### **Monument Glamping 1, PPR-24-43 (Revised Comments)**

**Please accept the following comments from El Paso County Public Health (EPCPH) regarding the proposed 6.44-acre lot special use referenced above:**

ELEVATIONS,  
SECTIONS, PLAN &  
STRUCTURAL  
SHEET  
**A1**  
OF 1 SHEETS

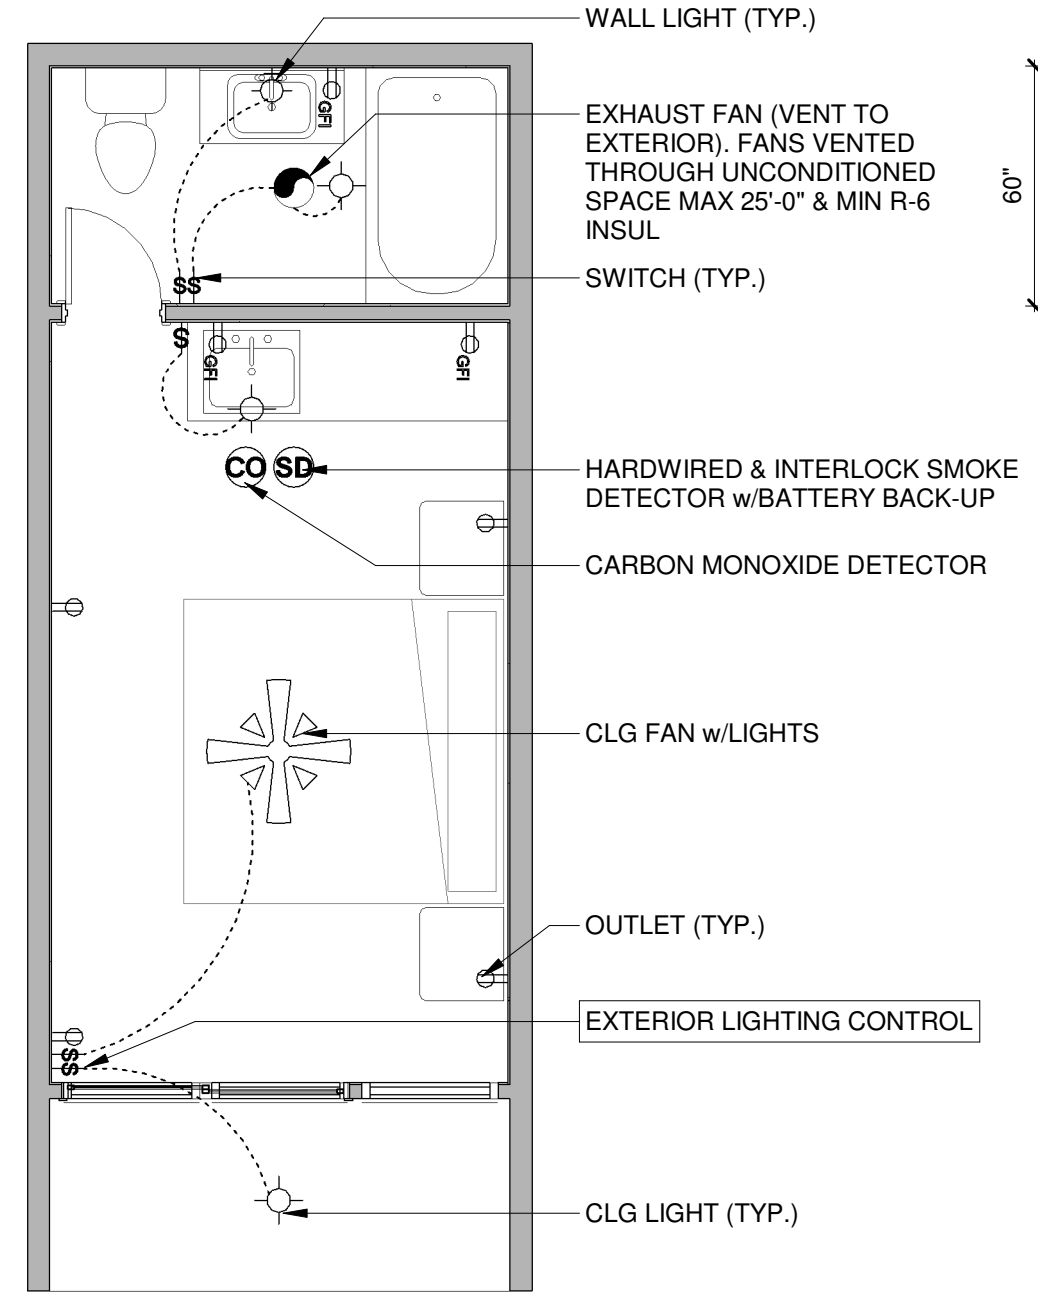
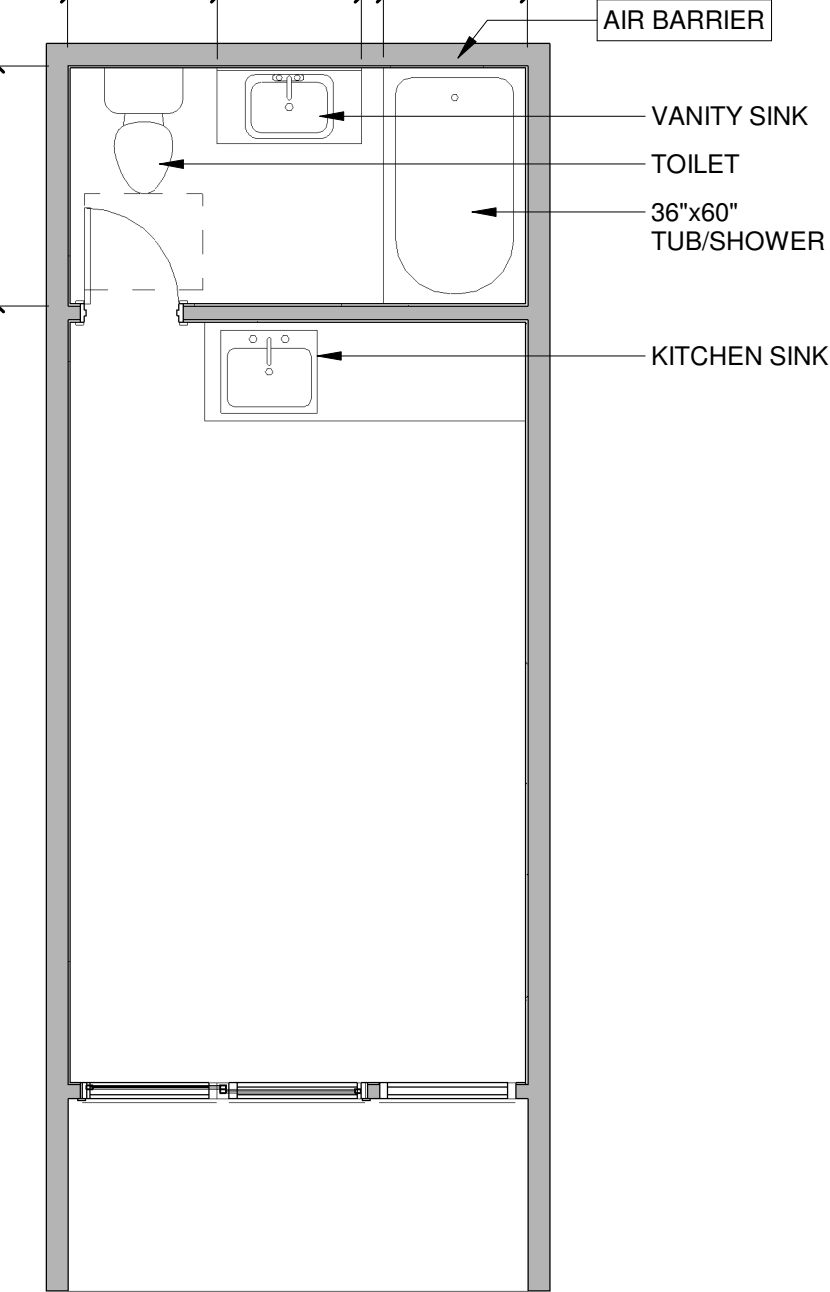
- **Is this still “glamping” or cabin rentals?**
- **The hard sided structures are pending approval by EPCPH. The addition of plumbing fixtures will alter wastewater flow calculations. The onsite wastewater treatment system (OWTS) engineer must coordinate the use of plumbing fixtures, if any, in these structures with the El Paso County Public Health, Water Quality Program Manager.**
- **The site lacks an approved OWTS design; therefore, currently wastewater service for the project is not approved.**
